**STATE SIGNIFICANT DEVELOPMENT APPLICATION 61400212  
APPLICANT: THIRD.1 GROUP**

**North Sydney Council Response to RTS  
25 Hume St Crows Nest Site B OSD**

**SITE:** 25 Hume Street CROWS NEST 2065  
SSD-61400212 - Crows Nest OSD Site B Proposed over station mixed use and residential development comprising of: 122 Residential units and 78 above ground car spaces

To provide urban design comments on the amended Development Application (SSD-61400212) – Crows Nest Metro OSD Site B (dated 19 August 2025). This advice should be read in conjunction with advice prepared in November 2024.

1 CLARKE LANE ELEVATION  
SCALE 1:200

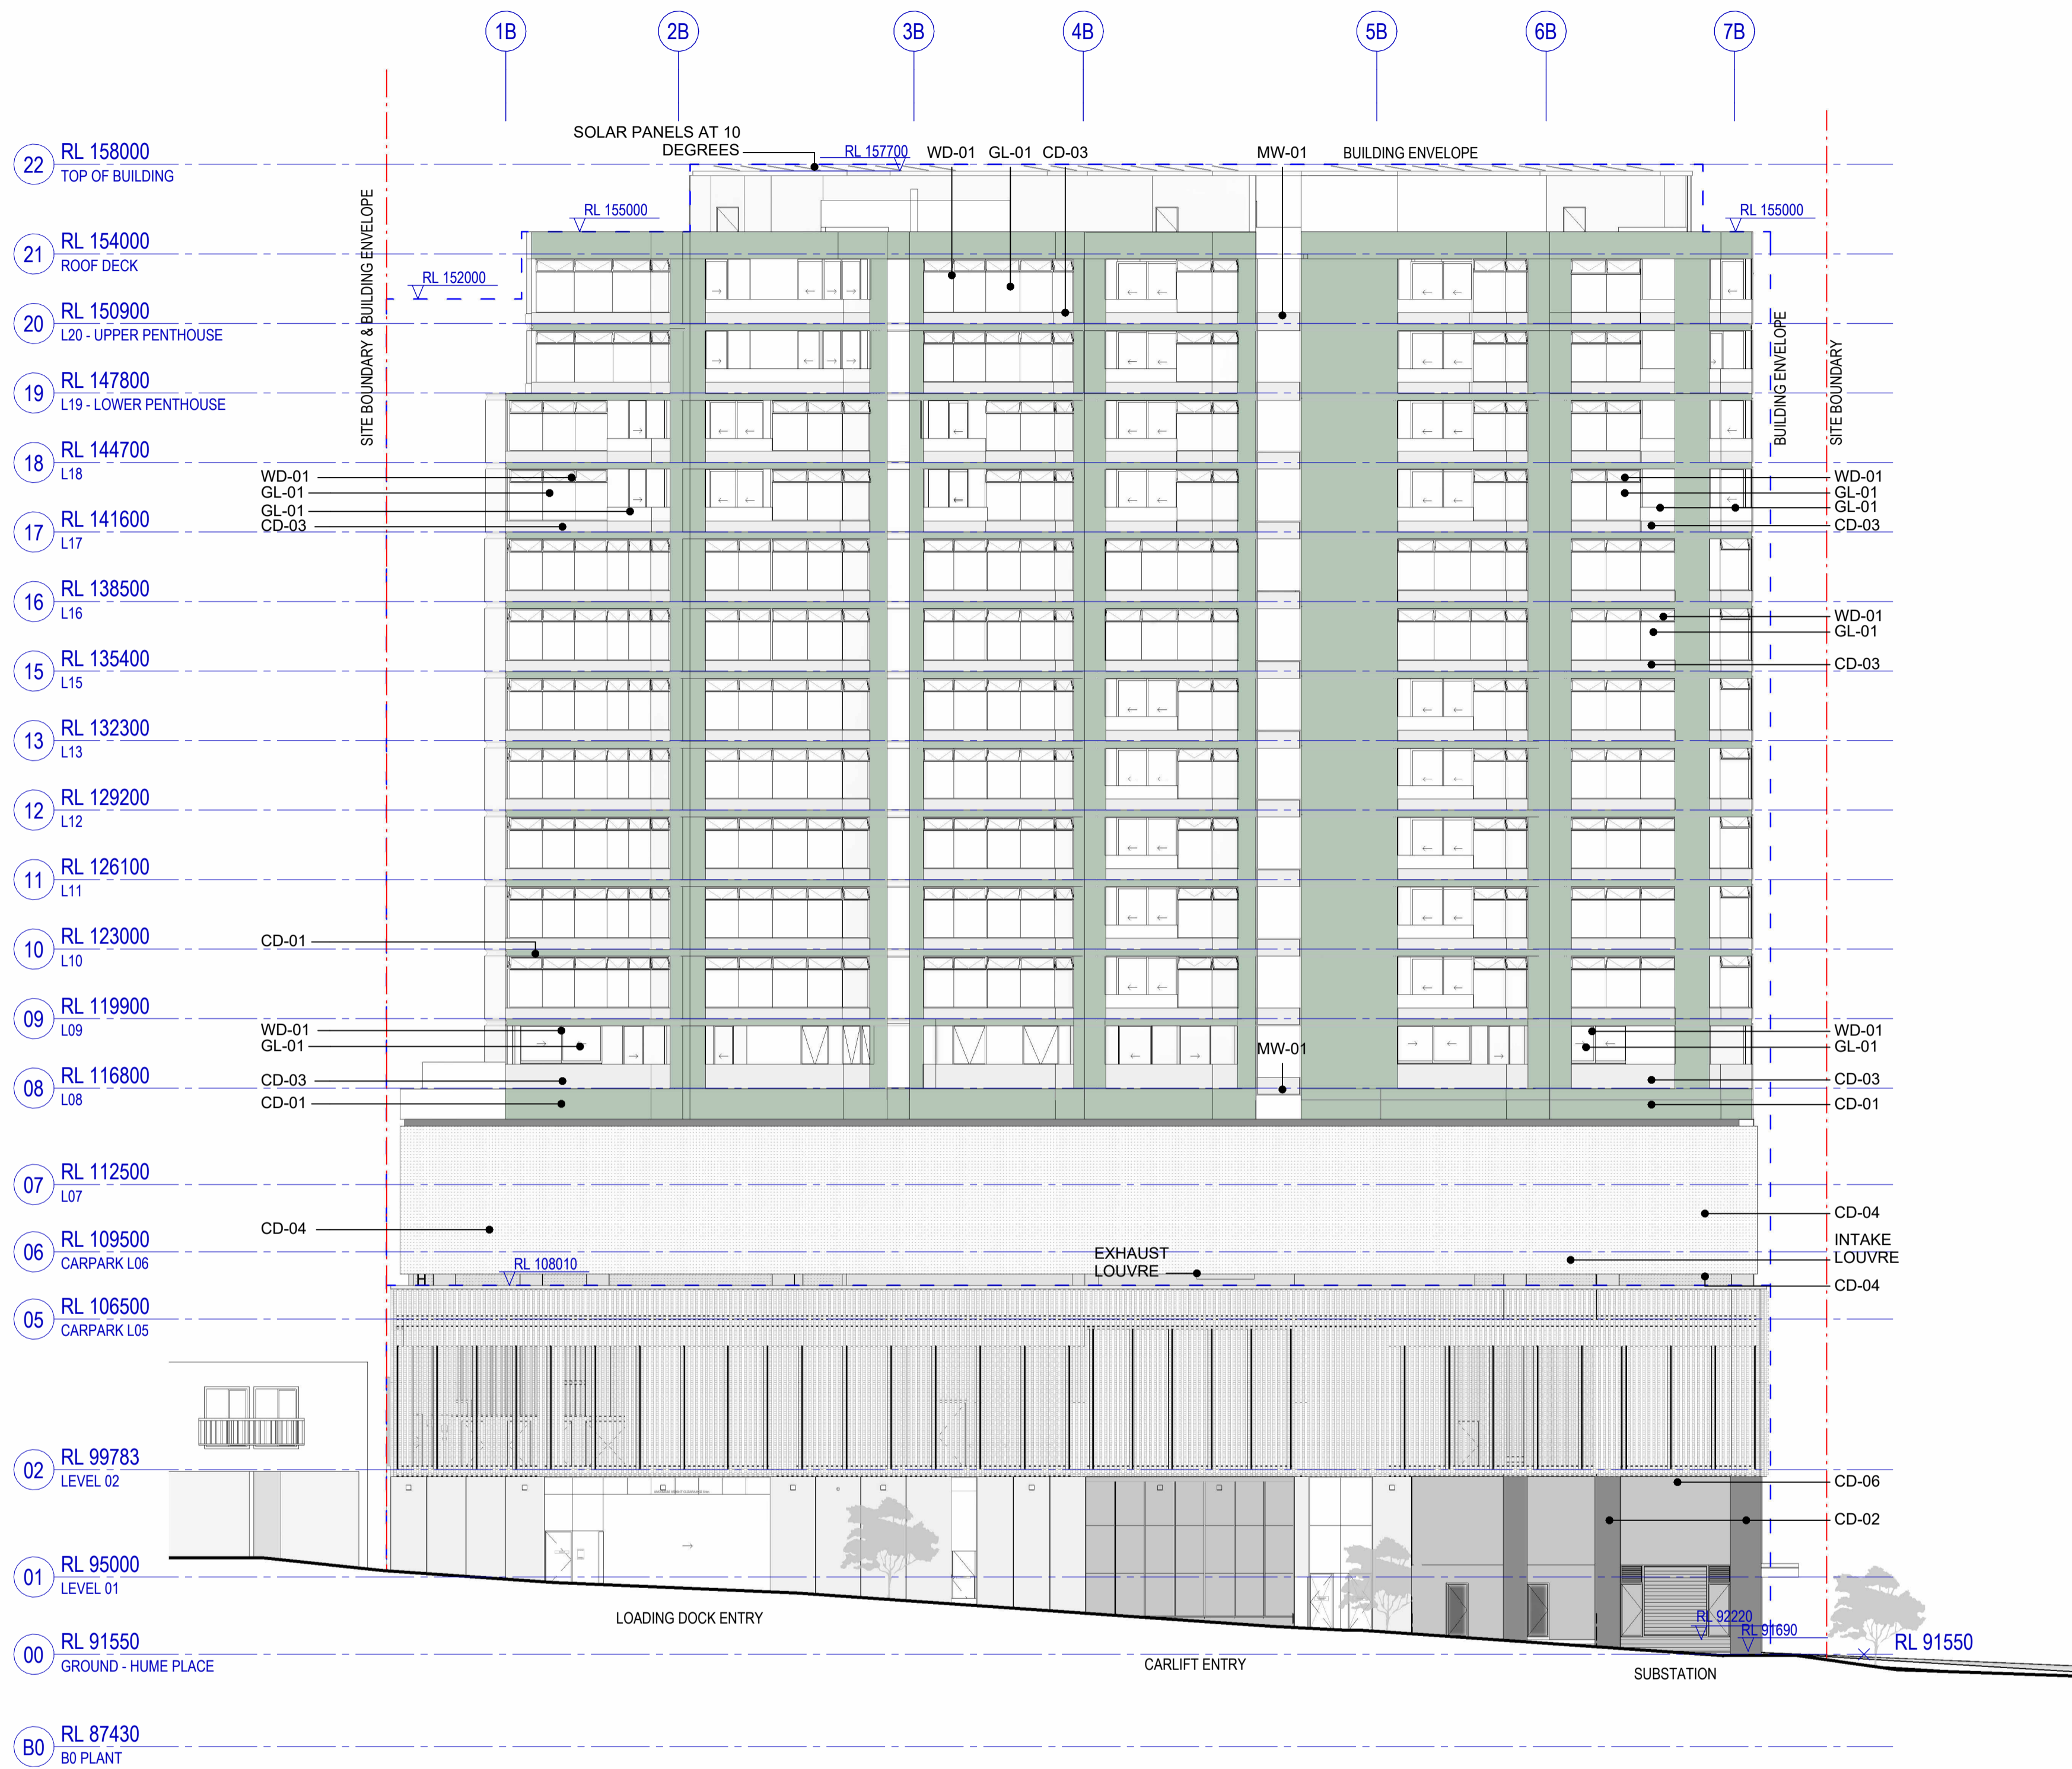
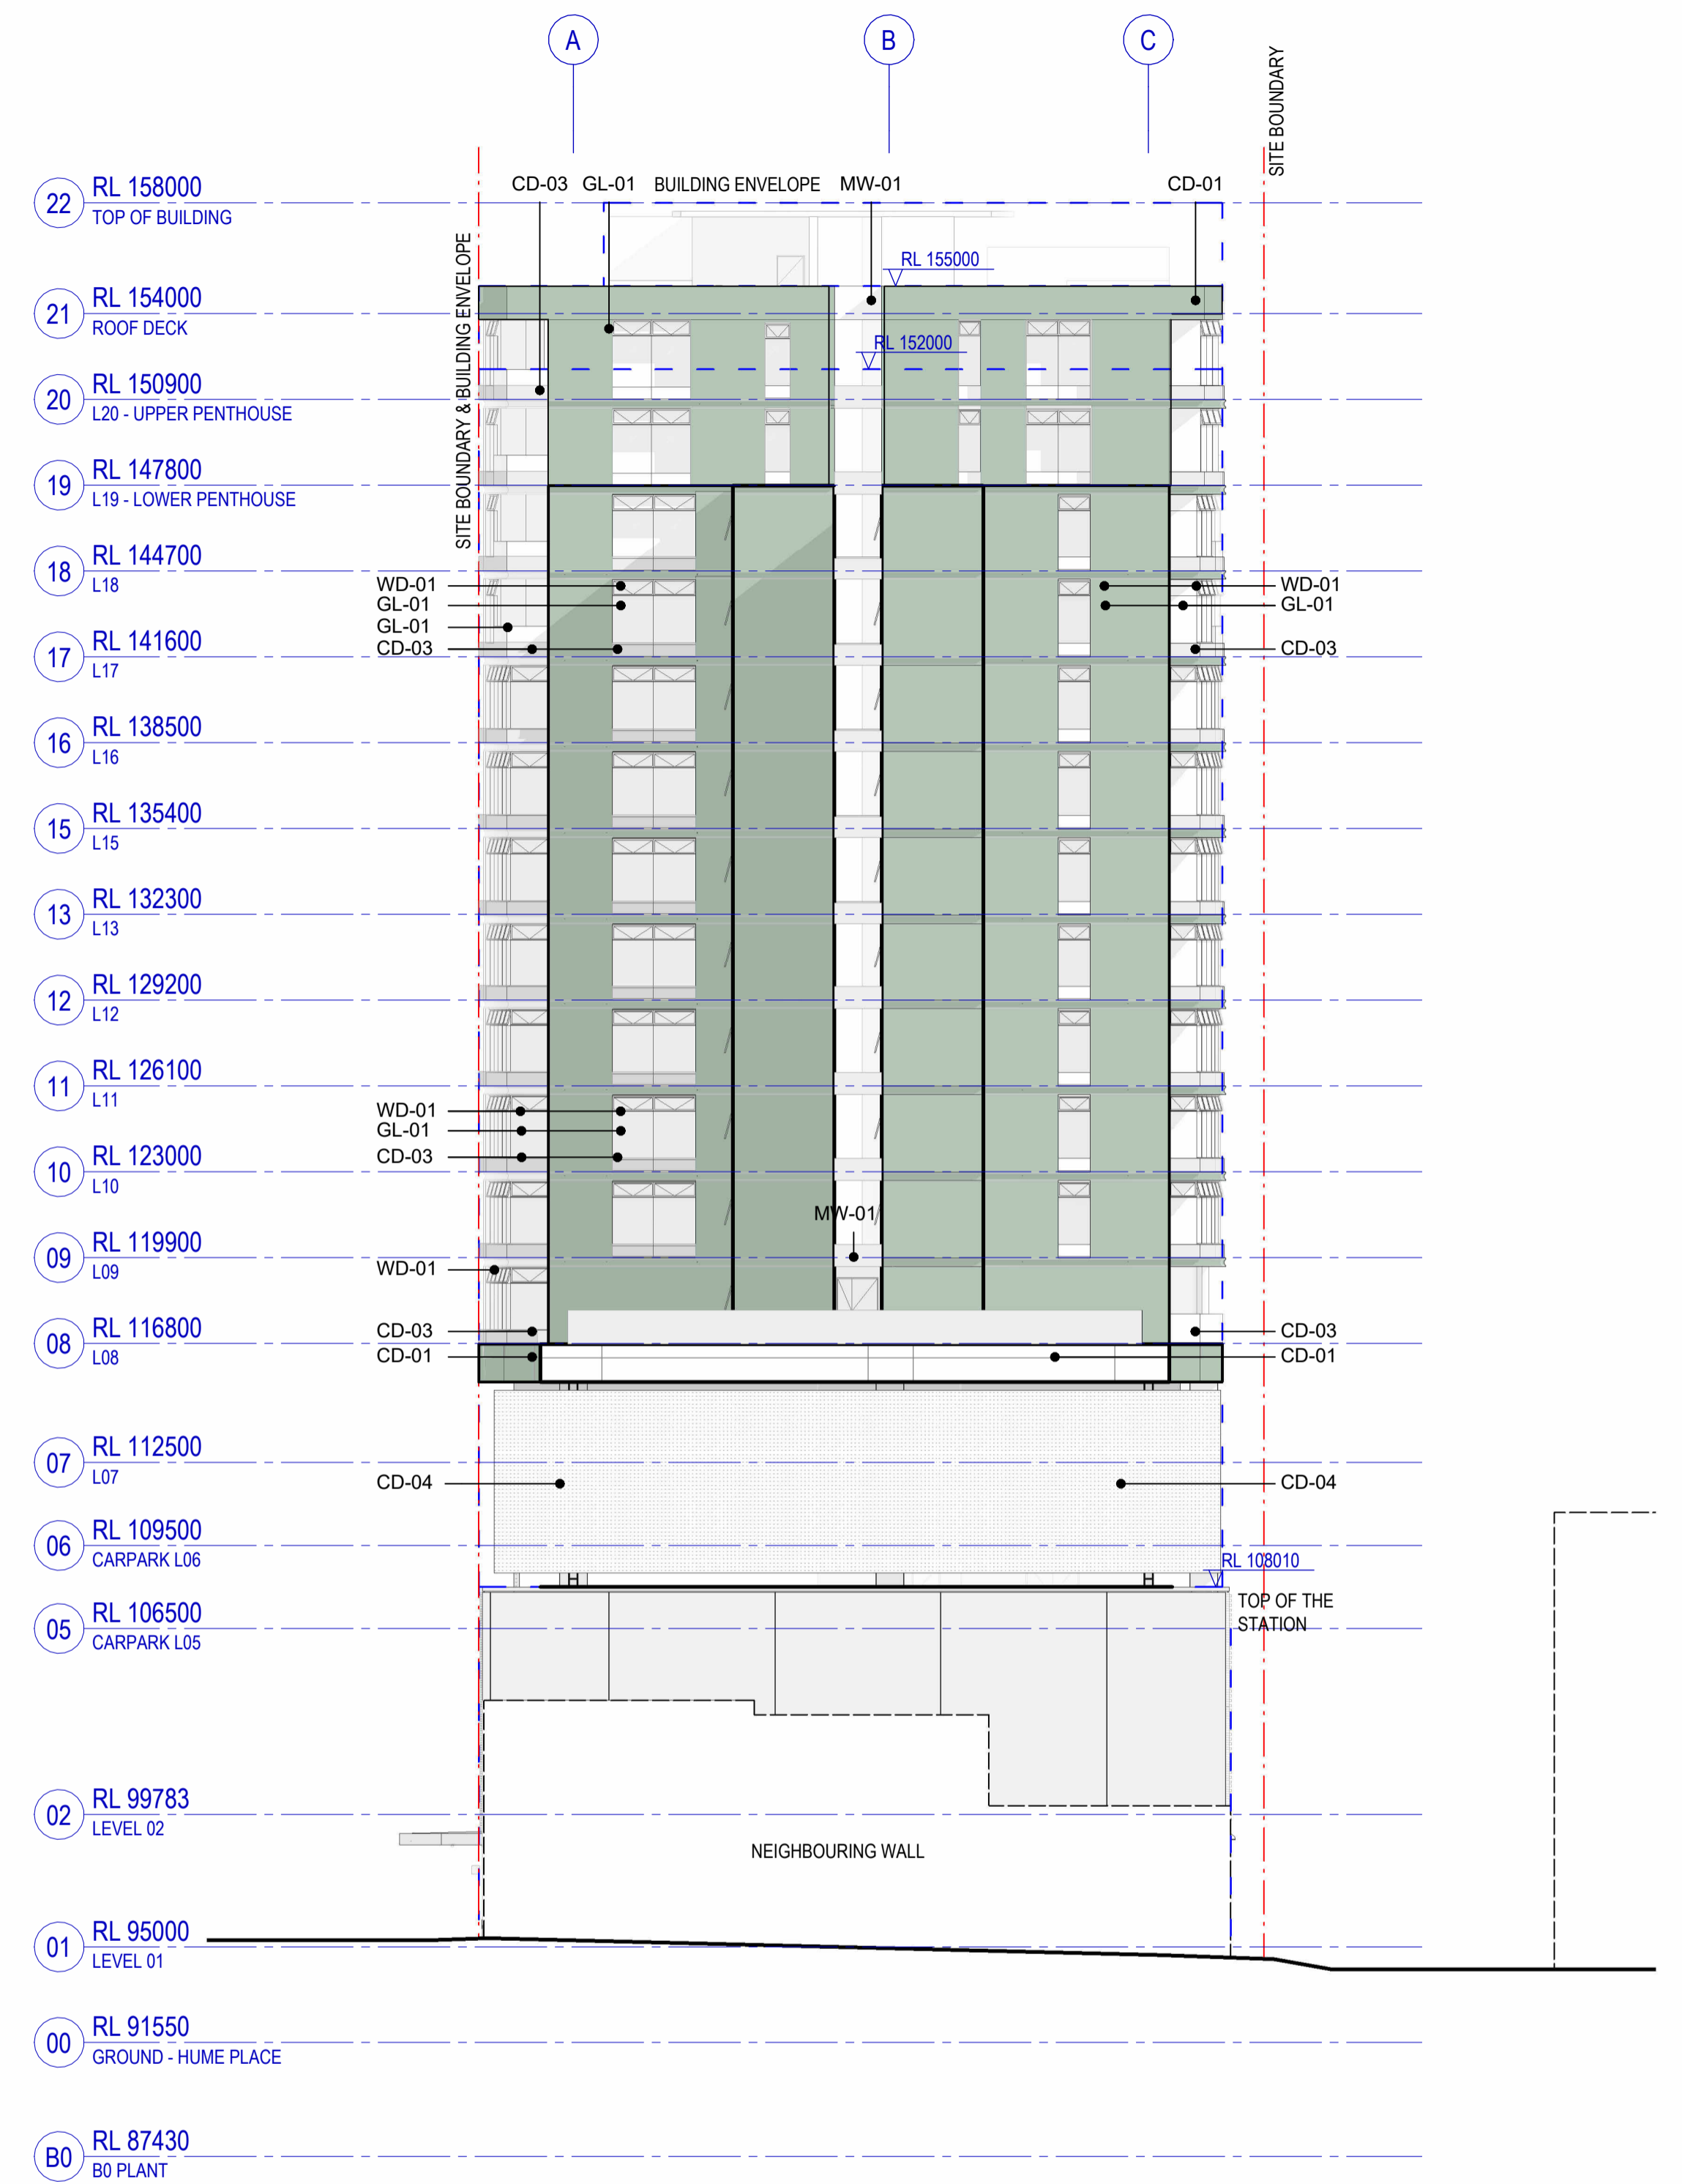
- 2.4 The proposed narrow separation from the southern site along Pacific Highway will exacerbate bulk, overshadowing, and create a continuous wall-like effect that will be highly visible from local viewpoints along the highway.

- 2.5 The proposed non-compliant setback on the eastern side to Clark Lane significantly compromises urban scale, privacy, amenity, and overall design quality for future residents on both sites.

- 3.1 The amended design adds a third car parking level (Levels 5–7), maintaining an almost no setback to the shared southern boundary. Previous Urban Design advice raised concerns that these open-façade (featuring perforated metal panels) car park levels directly interface with the adjacent site, which is planned for redevelopment with a 3-storey street wall and residential uses above.
